HERBATA DATA CENTRE, NAAS - RESPONSE TO REQUEST FOR FURTHER INFORMATION ("RESPONSE TO RFI") FROM KILDARE COUNTY COUNCIL

ADDENDUM TO CHAPTER 1 INTRODUCTION AND NEED FOR EIAR

NI2615
01
June 2025

This Environmental Impact Assessment Report (EIAR) Addendum is provided in response of the Request for Further Information (RFI) from Kildare County Council (dated 4th October 2024) in respect of the proposed Herbata Data Centre Campus (the Project) which is subject of planning application reference 24/60787. The Kildare County Council RFI is provided in Volume II, Appendix 1.1.

Drawing file: 1. Design Drawings / 04. 22217-RKD-ZZ-ZZ-DR-A-1010-OVERALL PROPOSED SITE PLAN.pdf

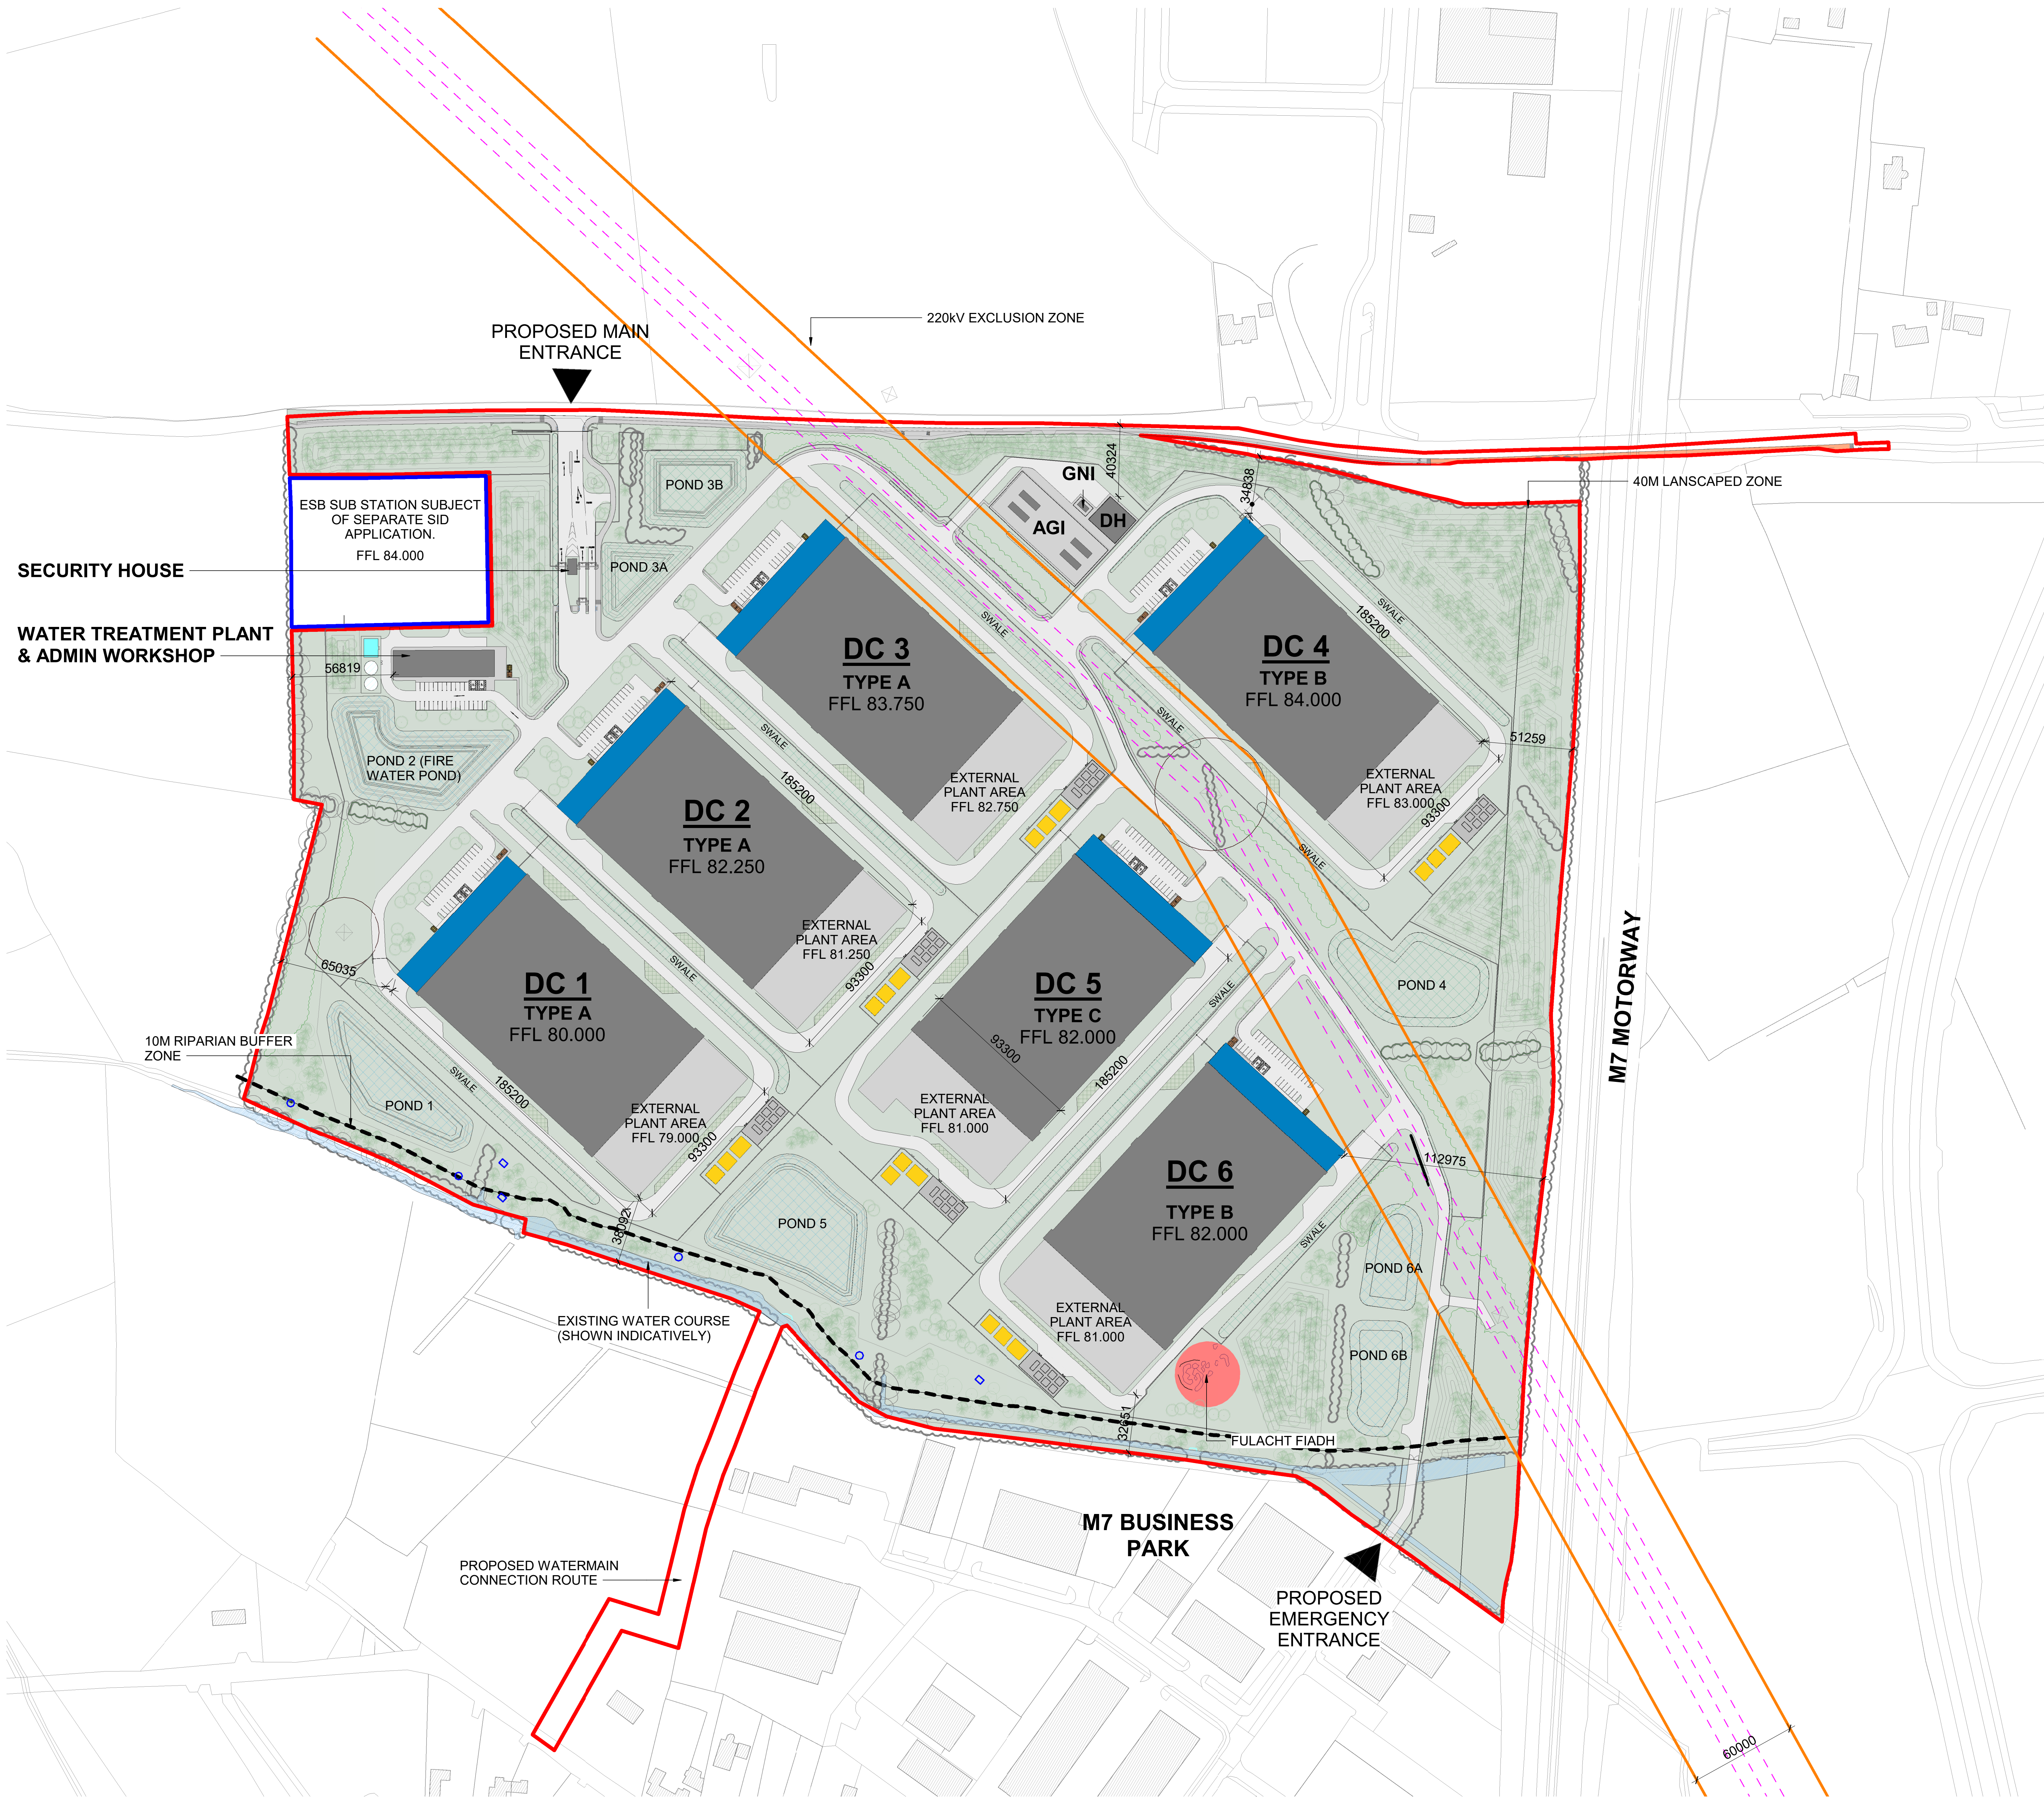
An amended design is proposed for Data Centre 4, primarily in respect of the arrangement of the proposed energy plant area (to the rear of the building) and subsequently, the overall plan of the building.

The amended design of Data Centre 4 is in response to the Kildare County Council RFI (Item 25) having considered the potential archaeological feature identified to the south east corner of the building; further detail and consideration of this is provided in the Addendum to Chapter 10 Cultural Heritage of the EIAR.

The external plant gantry and enclosed yard to the rear (encompassing the building energy infrastructure) of Data Centre 4 remains largely consistent with the description set out in the submitted EIAR however the arrangement of the energy infrastructure has been altered to reflect the amended building design.

In order to accommodate the amended design of Data Centre 4 building, minor amendments to the layout of ancillary elements (such as security fencing, access road, drainage etc) which are within immediate vicinity of the building, are proposed. The component elements of Data Centre 4 (as summarised in Section 1.2 (a) above), the location within the overall site, building height, materials and finishes, remain unchanged.

For the purpose of comparison, Figures 1.1 and 1.2 below, illustrate the previously submitted site context plan and the amended, proposed site context plan respectively.
